**RE: EASTERN CREEK QUARTER - LOT 3 CONCEPT PLAN (SSD-10457)**

Ethos Urban has prepared this letter on behalf of Frasers Property Australia Pty. Ltd (Frasers) in response to the Department of Planning and Environment's request for information (RFI) letter dated 22 February 2022. It is accompanied by the following additional information provided by the relevant technical experts:

**Table 1**      *Response to TfNSW Comments*

ROOTY HILL ROAD SOUTH / CHURCH STREET  
INTERSECTION LAYOUT  
AND VEHICLE SWEPT PATHS  
(Prepared by Henry and Hymas)

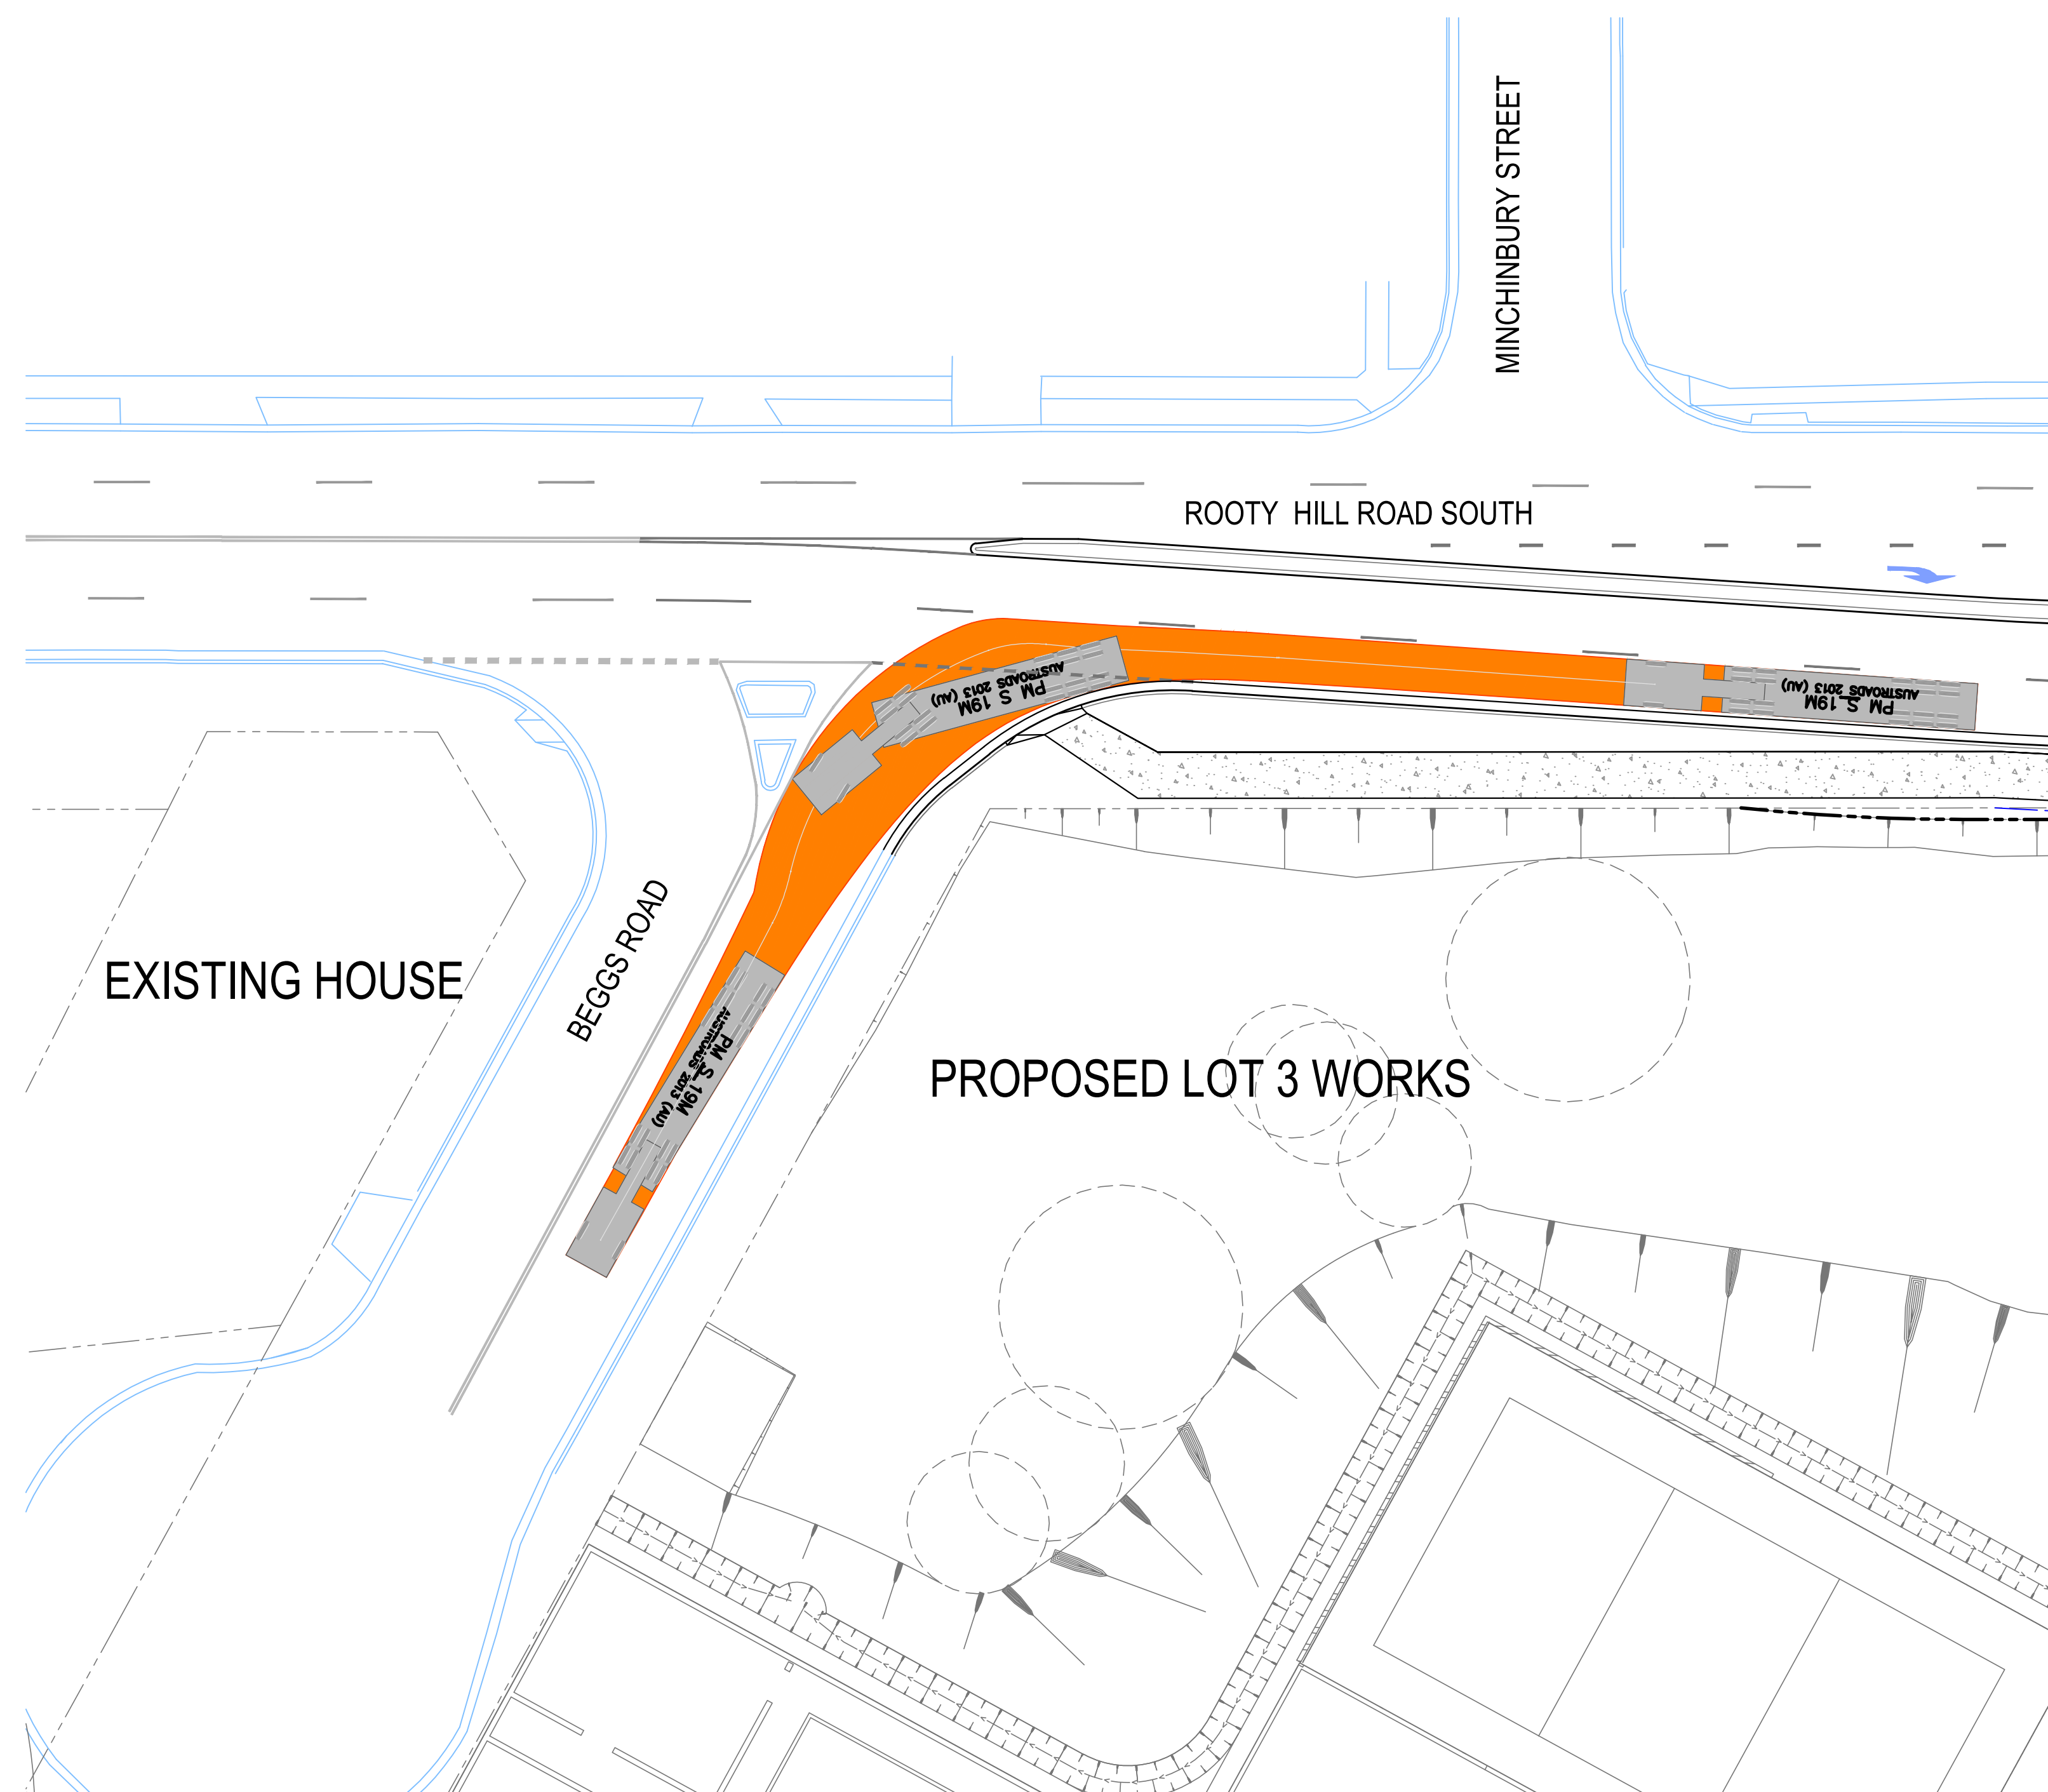
Comment	Response
1. The pedestrian crossing on the northern leg is to be located closer to Church Street. As a result the existing drainage pit at the northwest corner will require relocation.	As shown on the concept intersection design ( <b>Attachment B</b> ), the pedestrian crossing on the northern leg of the intersection has been located closer to Church Street and the existing drainage pit will be relocated.

2. It is understood that a kerb ramp exists at the northwest corner which is used as a driveway by the resident. Once the marked crossing is installed, this kerb ramp should be removed and reinstated to match existing kerb and gutter.	As shown on the concept intersection design ( <b>Attachment B</b> ), the kerb ramp will be removed, and the kerb and gutter will be reinstated as requested. It is noted that this is not a formalised driveway, and that the resident of this property has driveway access directly from St Agnes Avenue.

4. The turn path for MRV turning left from Rooty Hill Road South into St Agnes Avenue encroaches on the kerb, please address this issue.	As shown on the Turning Paths diagram at <b>Attachment B</b> , the MRV turning path has been amended to avoid encroachment onto the kerb.

5. TfNSW raises no objection to the Rooty Hill Road South realignment near Beggs Road with the suggested radius. At the 65m length from the stop line, the width of the right turn lane taper is 2.5m, which can only accommodate a car. It is recommended that	As recommended, the median width has been reduced to 1.2m from Beggs Road and then transitioned through to taper to 1.5m. Refer to <b>Attachment B</b> .

Comment	Response
<p>the median width be reduced to 1.2m from Beggs Road and then transition through the taper to the 1.5m median width. This will allow the width in this area (65m from stopline) increased to 2.9m providing a better outcome.</p> <p>6. TfNSW notes that there is an existing driveway at the southwest corner of St Agnes Avenue. On safety grounds, the driveway should be relocated to St Agnes Avenue, providing a safer access to the resident also in addition to other road users. Please note, it is the responsibility of applicant to obtain written agreement from the landowner, permitting the relocation and any works required by the applicant.</p>	<p>AS280.1-2004 permits domestic driveways to be located within intersections such as that currently located at the south west corner of St Agnes Avenue and therefore the current driveway could remain in its current location. Notwithstanding, Frasers is willing to pursue the relocation of the driveway at the request of TfNSW as a mitigation measure of the development.</p> <p>A design solution has been provided to relocate the driveway to St Agnes Avenue (<b>Attachment B</b>) and this will require a commercial agreement with the resident to implement this, should they agree. Prior to this occurring, certainty regarding the concept plan and TfNSW's endorsement of the intersection is required and, as such, a condition of consent should be imposed to facilitate this outcome. It is noted that if the landowner did not wish for the driveway arrangement to change, the existing driveway could remain which would still be compliant with the relevant design standards.</p> <p>It is noted that this approach for a condition is supported by a recent LEC judgement whereby the commissioner noted that it is within the power of the court to condition a requirement for works on adjacent land and that there would then be an obligation for the applicant to comply with the condition and gain consent of the owner to undertake the work (if required). Refer to Paragraph 132 of Enares Pty Ltd v City of Canada Bay [2022] NSWLEC 1375.</p> <p>Accordingly, the following condition of consent is requested:</p> <p><i>The applicant must consult with the owners of the land at 134 Rooty Hill Road South, Eastern Creek in regard to the relocation of the driveway to St Agnes Avenue. If the landowner agrees to the driveway relocation, then the applicant must implement these measures as part of the WAD process for the intersection to the satisfaction of Planning Secretary.</i></p> <p><i>If the applicant and the landowner disagree on the scope of works to be implemented, then either party may refer the matter to the Planning Secretary for resolution.</i></p>
